From: Garry Mount [REDACTED]
Sent: 09 October 2014 16:58
To: Janice Chapman
Subject: Quince cottage - BN/32/14/HH
Attachments: 2014-26-03 Site plan-Layout1.pdf; Quince Cottage - Sketches.pdf

Re: Quince Cottage, Church Lane, Barnham.
Your ref: BN/32/14/HH

REVISION		
PROJECT	Proposed extension and alterations to Quince Cottage, Church Lane, Barnham	
SUBJECT	Site Plan, Location Plan and Plan and elevations of proposed garage	
SCALE	DATE	DRAWING No
DRAWN	AUG 2014	2014 / 26 / 03
	CHECKED

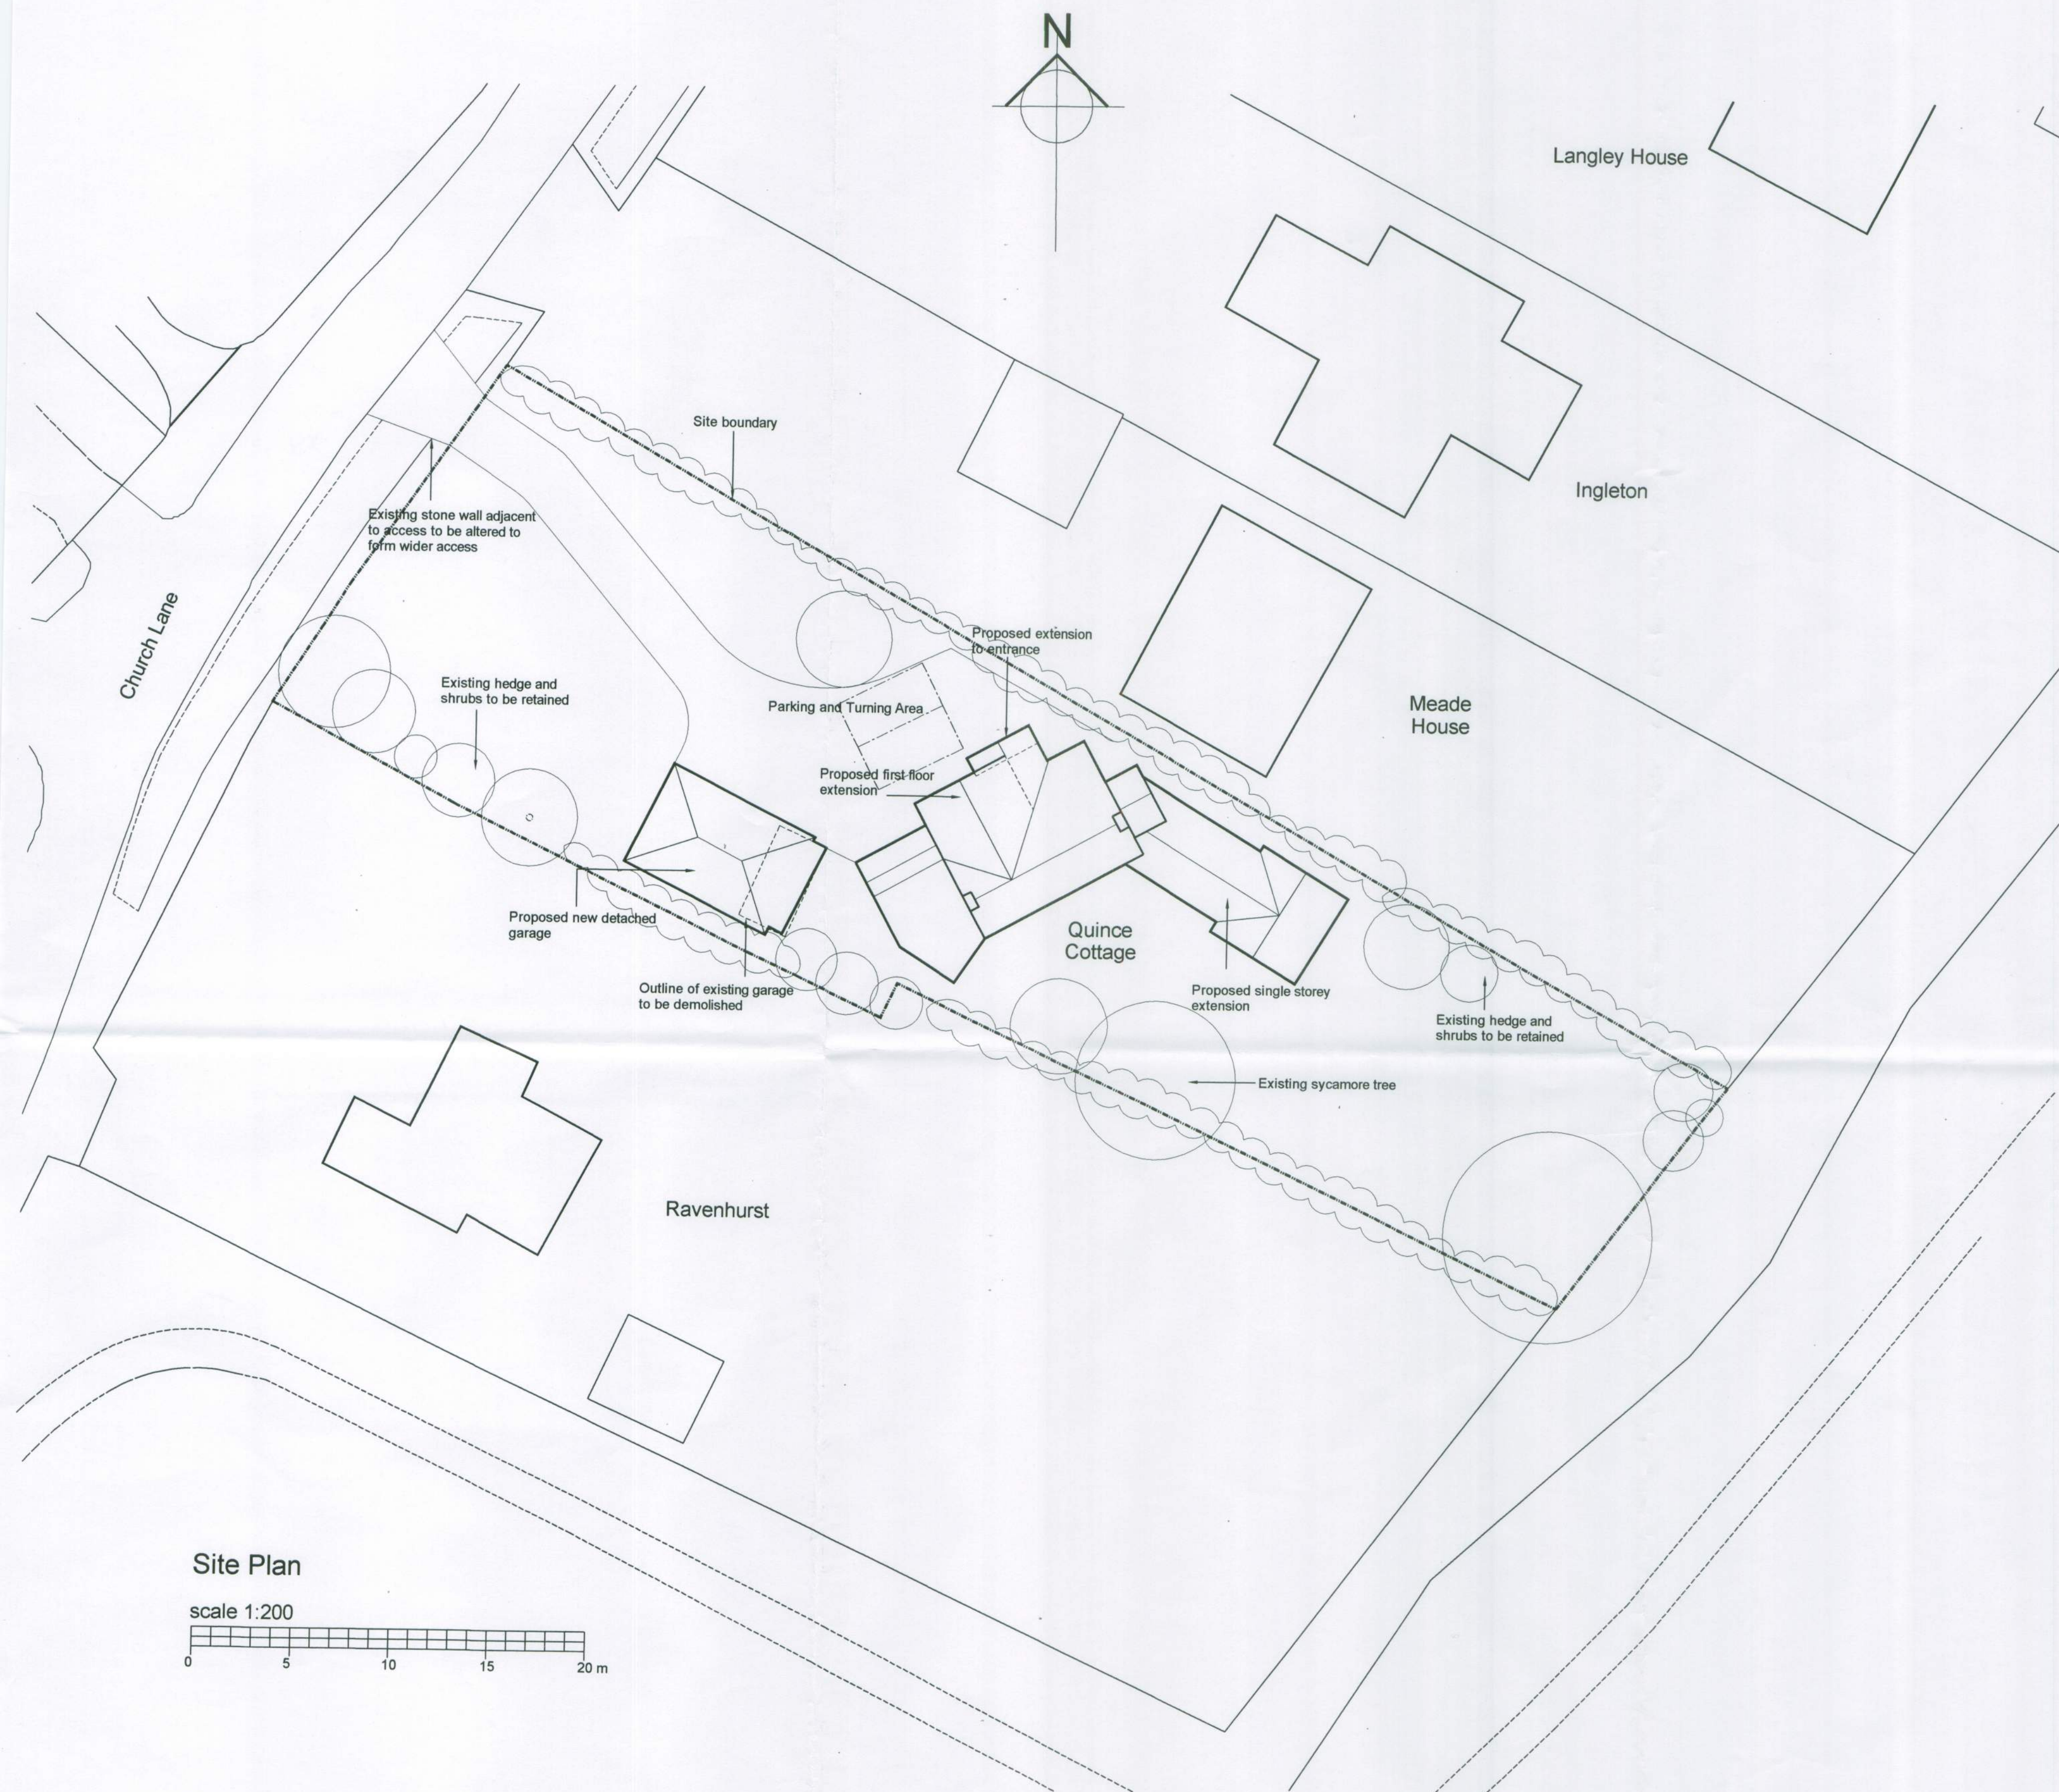
Following our telephone conversation earlier today, I have measured the conservatory to the rear of Meade House and added this to the site plan. I have also plotted on the site plan a line at 45 degrees which projects from the rear corner of the single storey extension to the side of the conservatory.
